PLANNING CONSULTATION RESPONSE

Application No	<u>2026/0354</u>
Proposal	Erection of a residential care home consisting of 6 single bedroom self-contained units and a detached 2 bedroom respite bungalow for young adults (Use Class C2) with associated works including formation of accesses; car parking and landscaping.
Address	Land West of Cross Street, Worsbrough Dale, Barnsley,
Date of Consultation Reply	21/09/26
Consultee	Highways Development Control

Site Plan 1:200

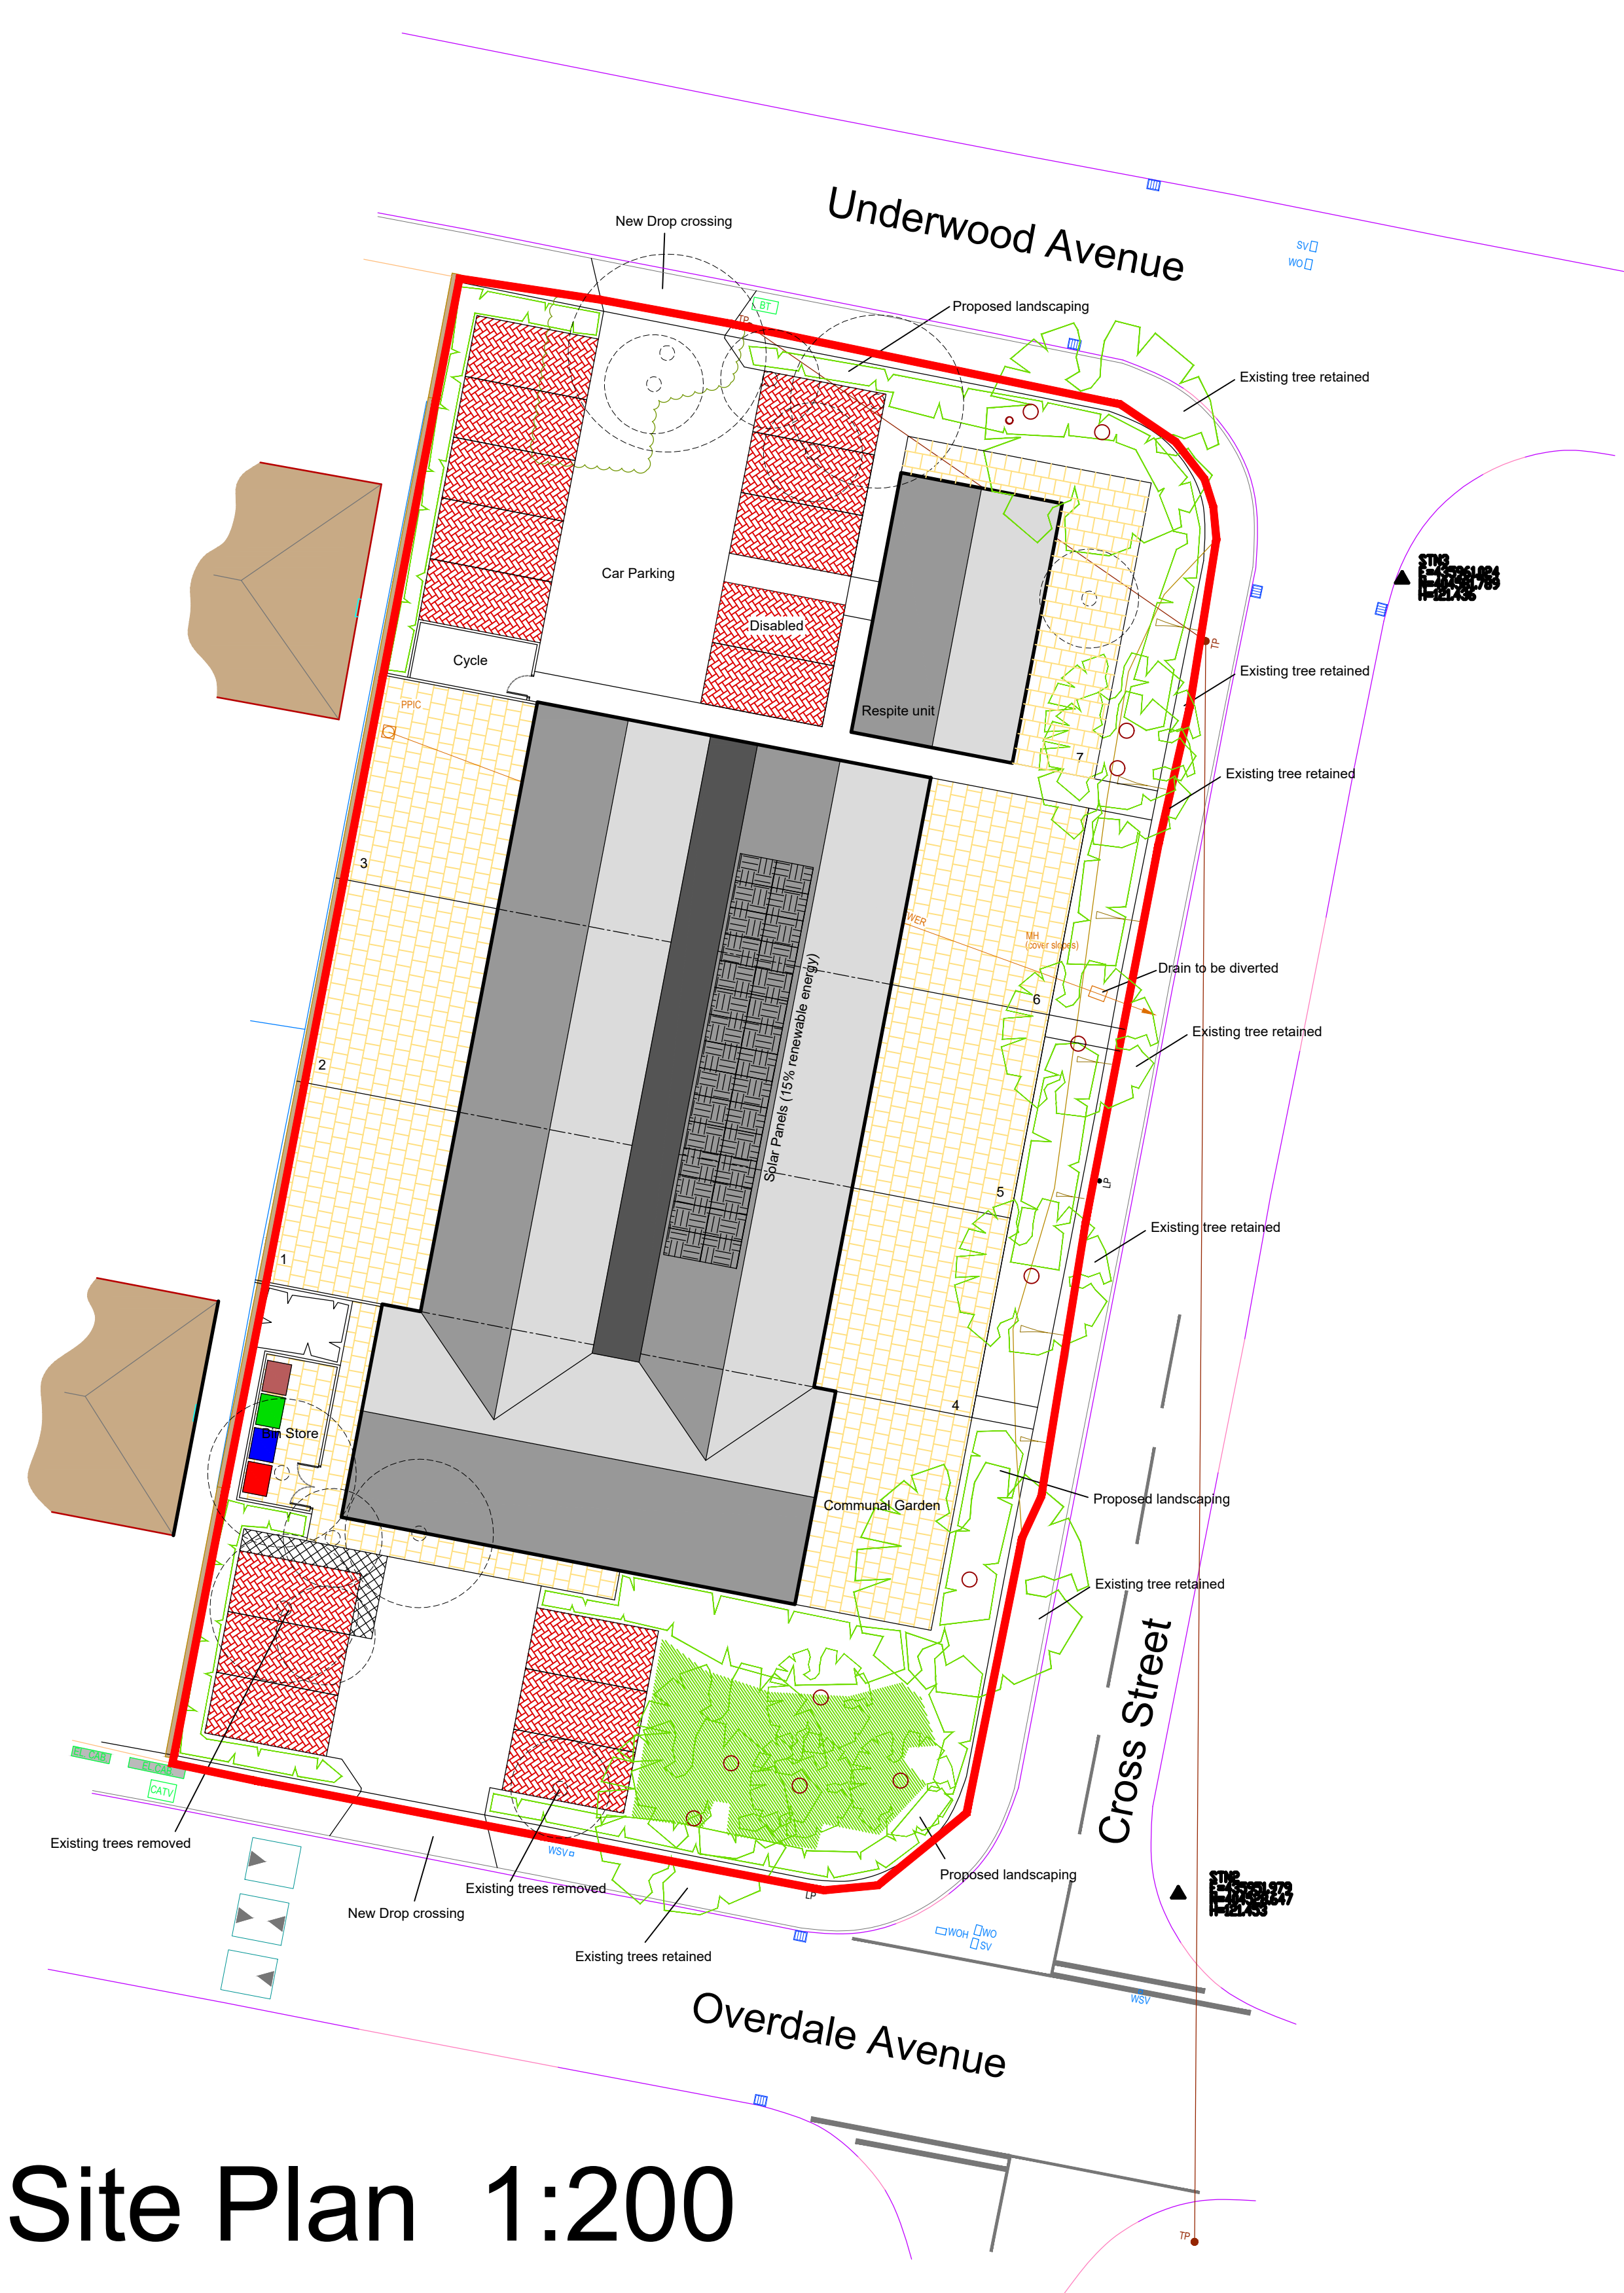
I agree that the applicant has responded positively to previous concerns by increasing the parking provision which includes two accessible bays, and that this level of provision is capable of accommodating the anticipated operational demands of the development.

With regard to cycle parking, I agree that there may be merit in reviewing amount of cycle parking provision to better align with the SPD requirements and encourage sustainable travel choices. However, given the nature of the proposed use and the overall parking demand considerations, I wouldn't want to reduce the parking provision by more than one space.

I agree that a CMP will need to be conditioned, and we can add a condition to ensure any boundary treatments do not exceed 600mm to protect and retain pedestrian visibility splays which I have detailed below.

Prior to the first occupation of the development hereby permitted, vehicular access shall be provided and thereafter retained in at the position shown on the approved plan (OD/JVND0C/3036/26.009 Rev C) and constructed in accordance with the BMBC highway specification. Arrangement shall be made for surface water drainage to be intercepted and disposed of separately so that it does not discharge from or onto the highway carriageway.

No building or use hereby permitted shall be occupied (or use commenced) until pedestrian visibility splays of 2 x 2m to the back edge of the footway / verge shall be provided at the proposed access. Nothing shall be erected, retained, planted and / or allowed to grow at or above a height of 0.6m to the rear of the footway which would obstruct the visibility splay. The visibility splay shall be maintained free of obstruction at all times thereafter for the lifetime of the development.
